Harwich Haven Authority acknowledges the importance of developing UK offshore renewable generation and is supportive of all initiatives that reduce carbon emissions and are aligned to net zero targets.

As the Statutory Harbour Authority and Trust Port our core remit is to provide safety of navigation to vessels using the waters within our 150 square mile jurisdiction area. Our jurisdiction covers a 12-mile approach to Harwich Harbour, the River Stour, and parts of the River Orwell. We are responsible for the conservancy of the main navigation channel into the Haven, which requires an ongoing maintenance dredging programme to maintain the depth required to accommodate the very largest and deepest container vessels in operation. We operate a 24/7, 365 day a year service to provide pilotage services to five port operators in the Haven, Port of Felixstowe, Navyard, Harwich International Port, Port of Mistley and the Port of Ipswich. The continuous, and uninterrupted flow, of vessels into the Port of Felixstowe is critical to UK trade, with approximately 40% of all containerised goods entering the UK via this gateway.

During development, construction and operation of the Fives Estuari

Figure 2.1: Overview of area of interest for NIP (including concurrent activity areas).

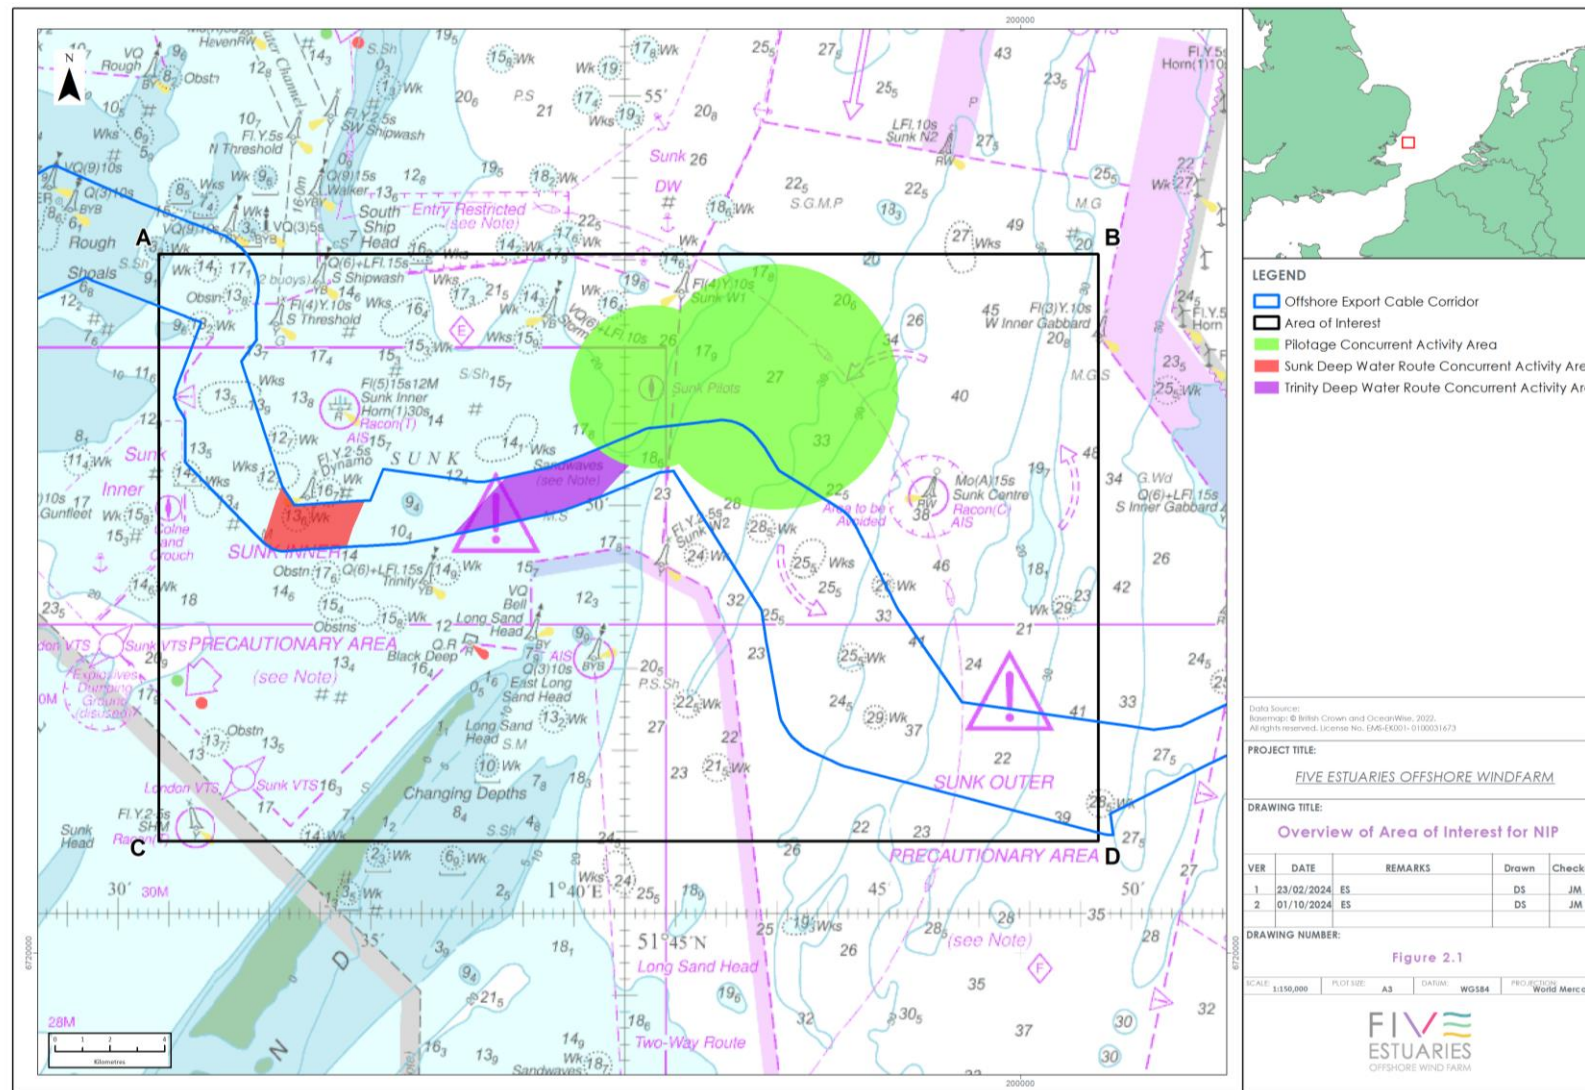
Requiring protective measures within the DCO to ensure that the cable route is at a suitable depth to ensure future deep draught vessels can navigate the Sunk area. The cable (and any covering material e.g. rock armour) must be at least 22 metres below Chart Datum to allow future vessel with a draught of 20 metres.

Controlling development and project construction related marine operations to ensure that there are no concurrent Restricted Ability to Manoeuvrer (RAM) operations occurring in the Sunk area. This must include the other DCO cable projects in this arear; North Falls project and the National Grid Sea Link project.

Exclusion zone(s) must not be put in place in the Sunk area or channel that would restrict 24/7/365 vessel access requirements or pilot boarding operations etc.

Safety zone(s) must not be able to impede vessel traffic movements within the Sunk area or normal operations such as pilot boarding.

In the Sunk area, cable depth needs to consider that the world's largest vessels may anchor and dredge anchors in emergency scenario.
